May 24, 2023

**Subject: BTR Storage Site Development Plan - (PPR2319)**

The Parks and Community Services Department has reviewed the BTR Storage Site Development Plan and is submitting the following administrative comments on behalf of El Paso County Parks.

ABTR STORAGE	SITE DEVELOPMENT PLAN
	DETAILS SHEET

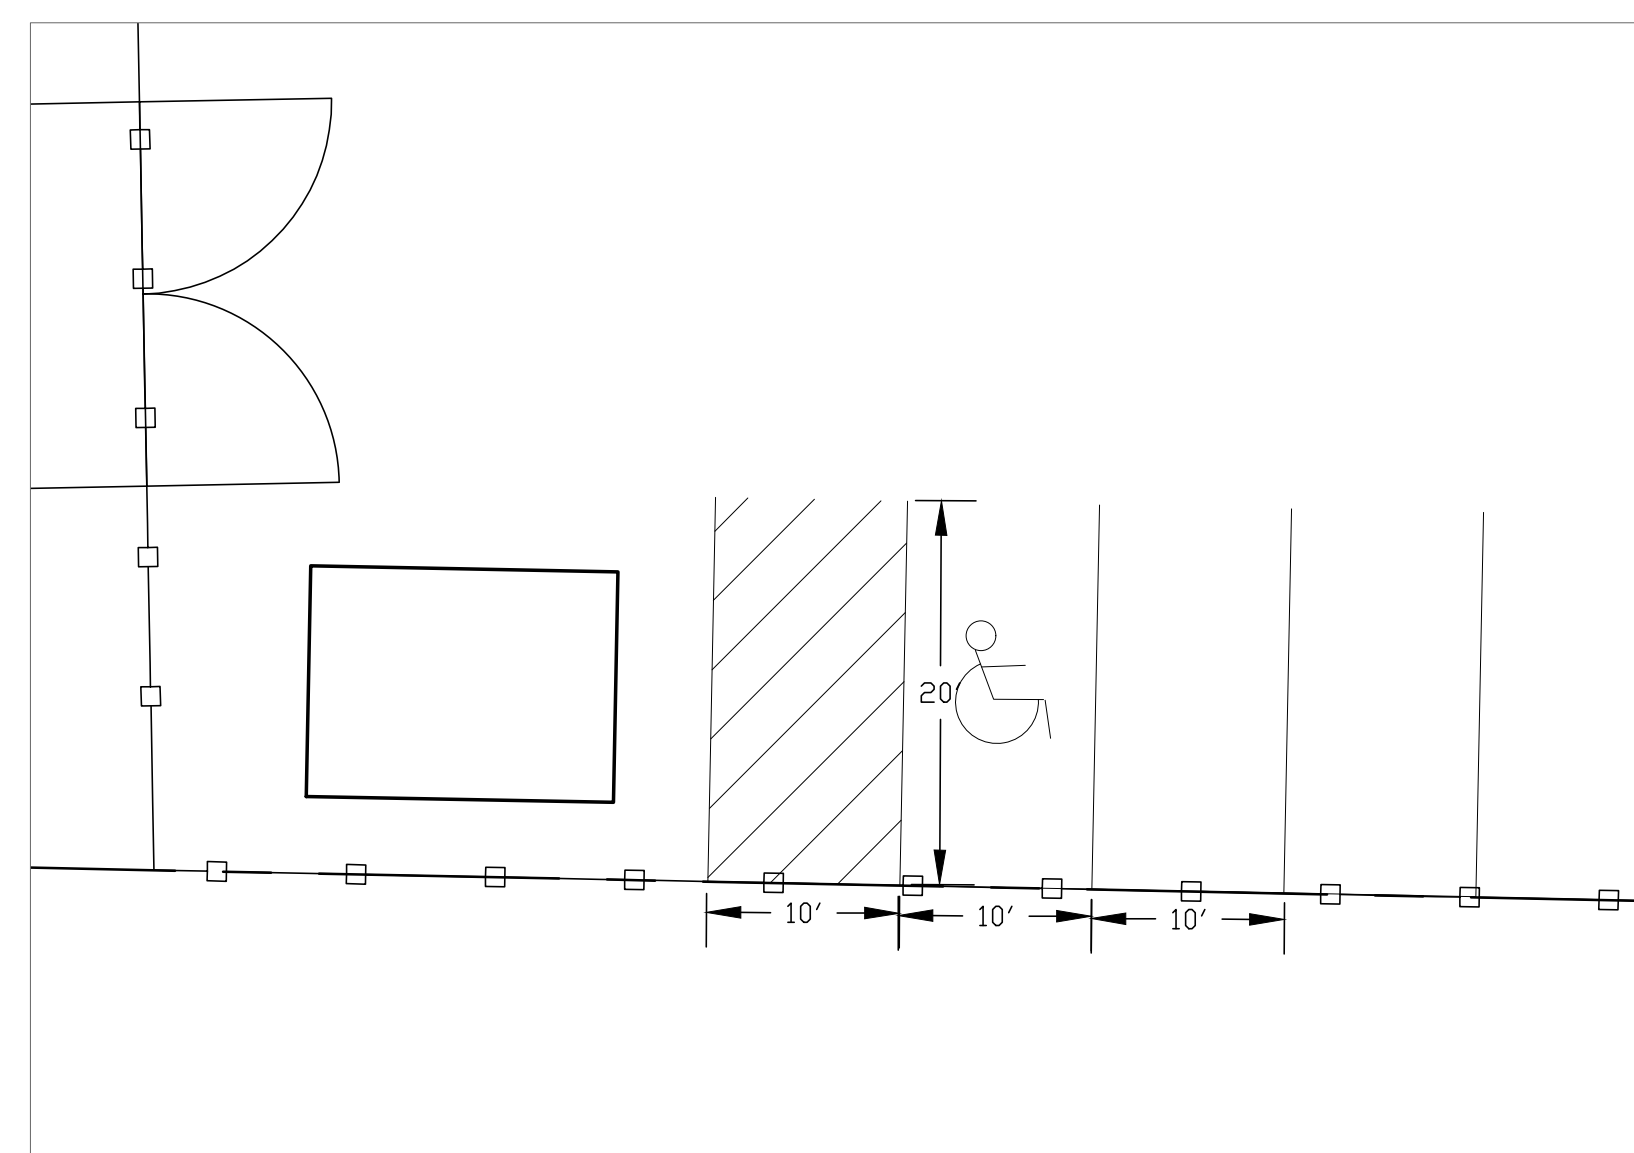
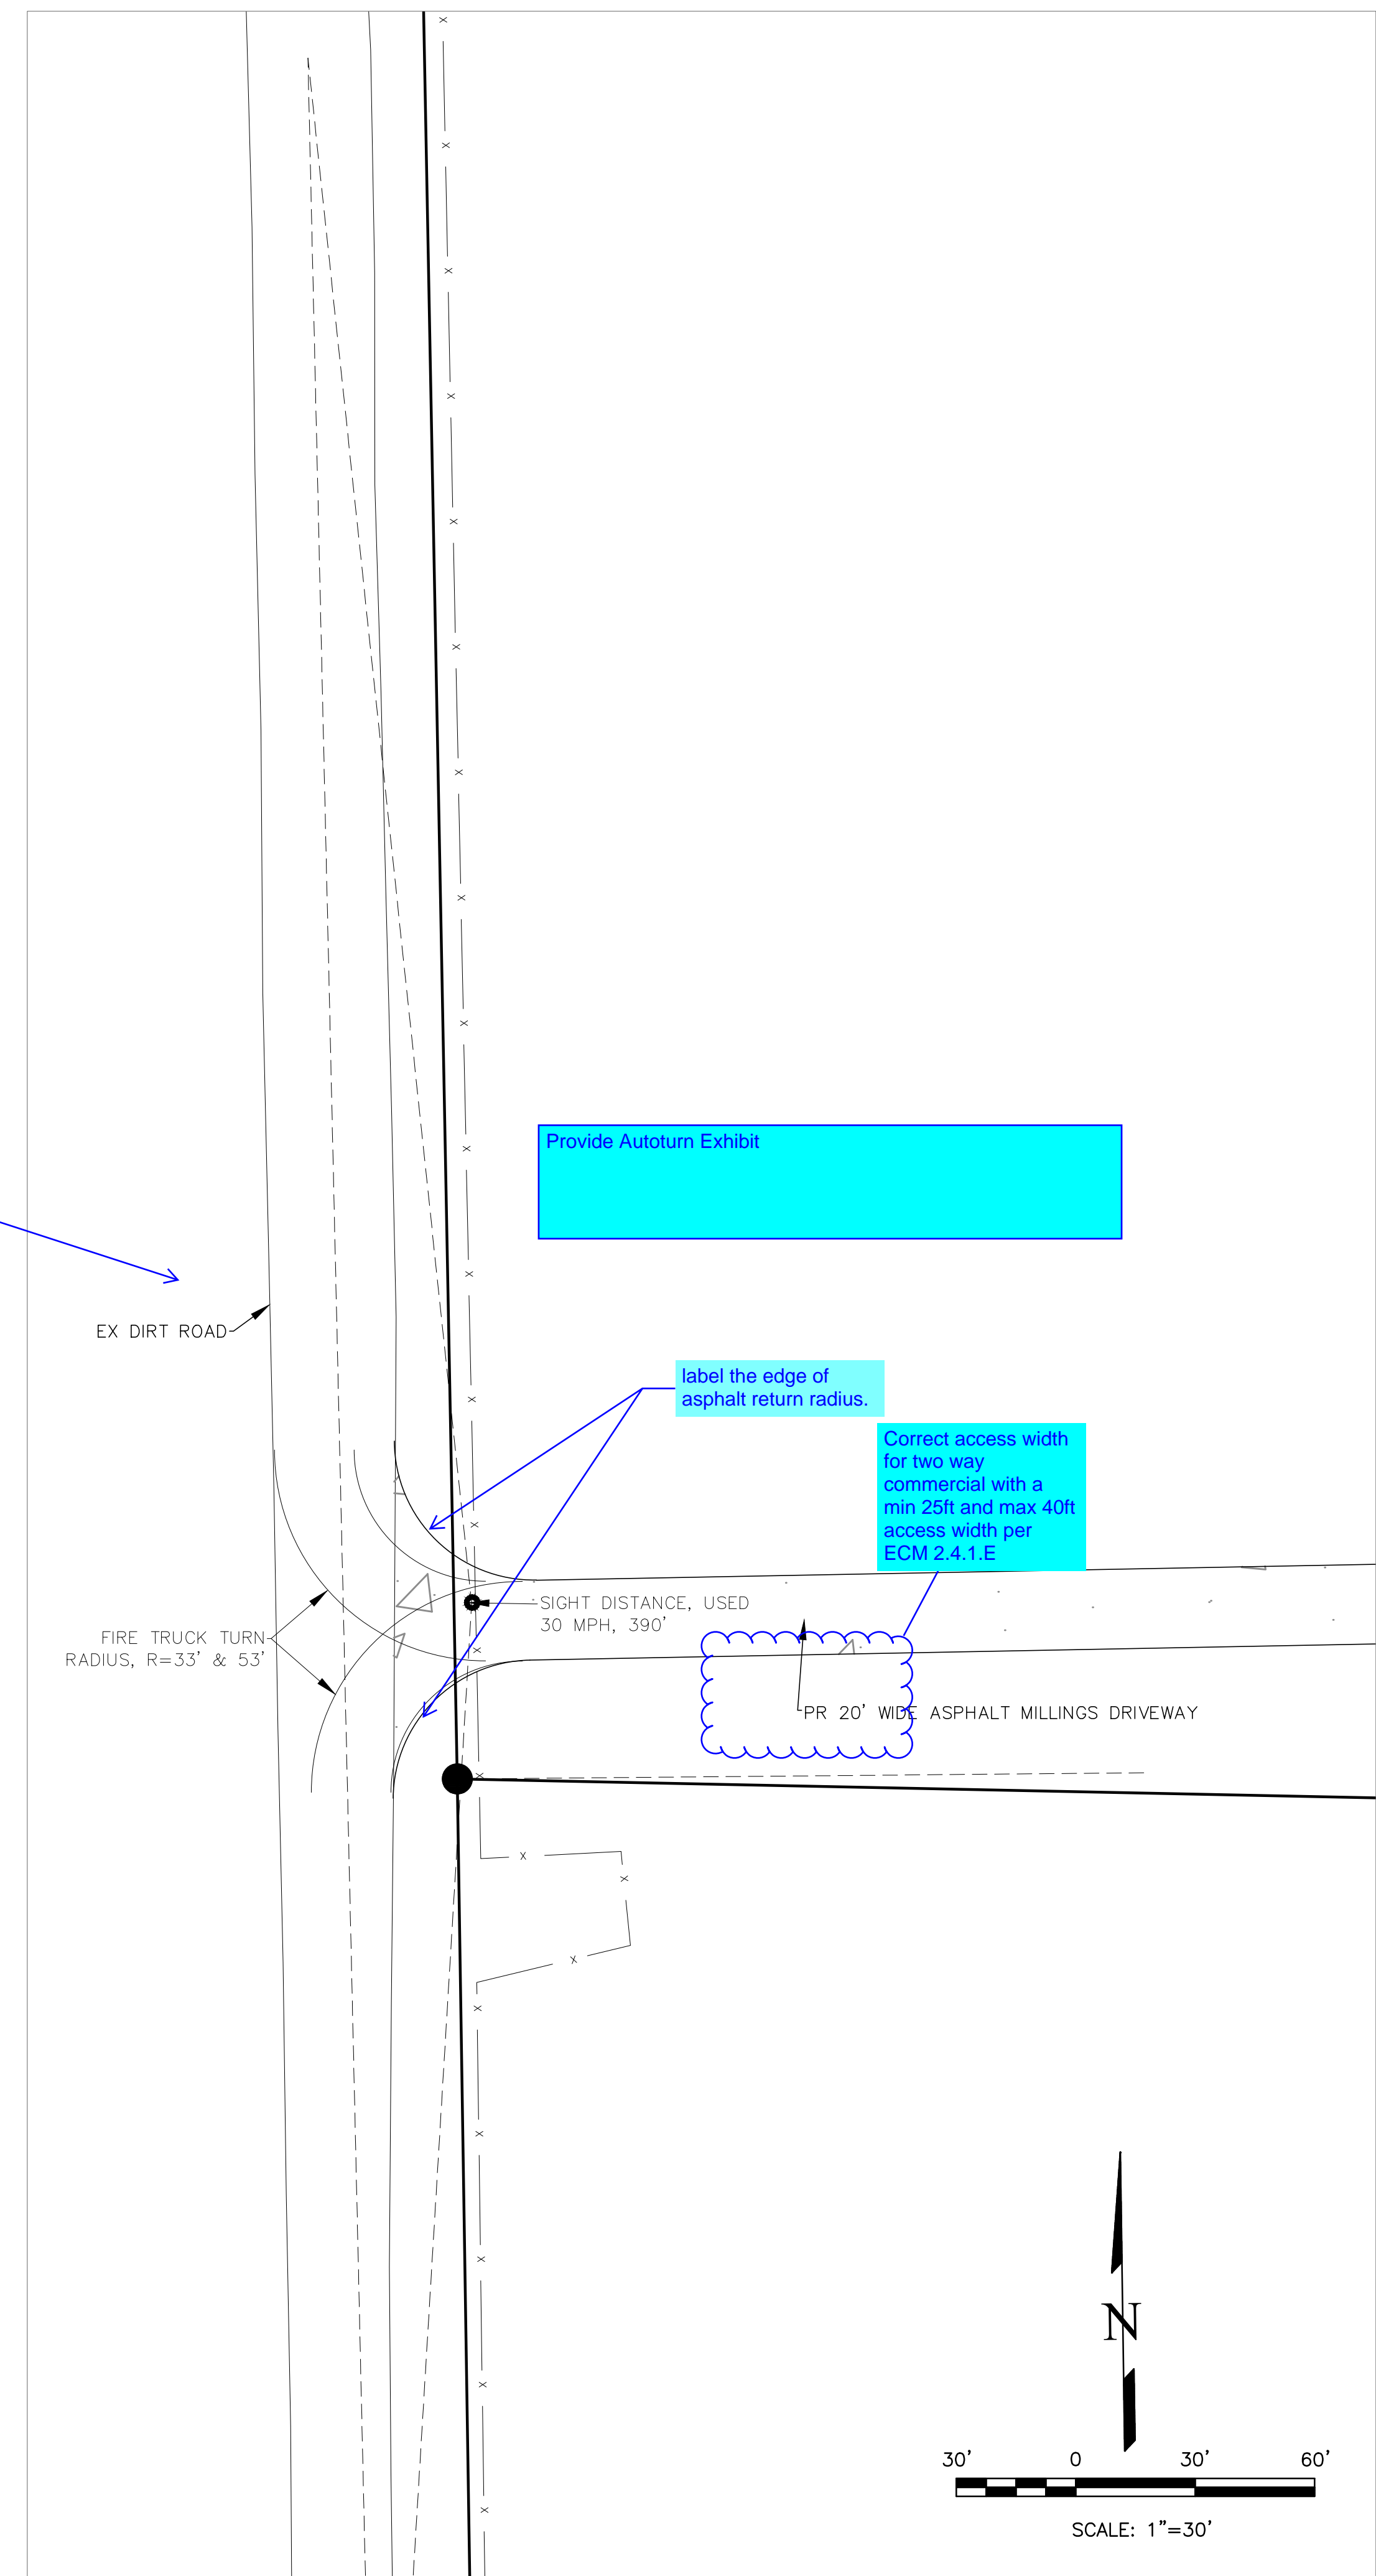
Parks staff provides notice that the Highway 94 Primary Regional Trail is planned for 25' south of the right of way of Highway 94. The County encourages that the landowner provide a 25-foot-wide public trail easement along the south side of Highway 94 that allows for the construction and maintenance by El Paso County of the Highway 94 Primary Regional Trail.
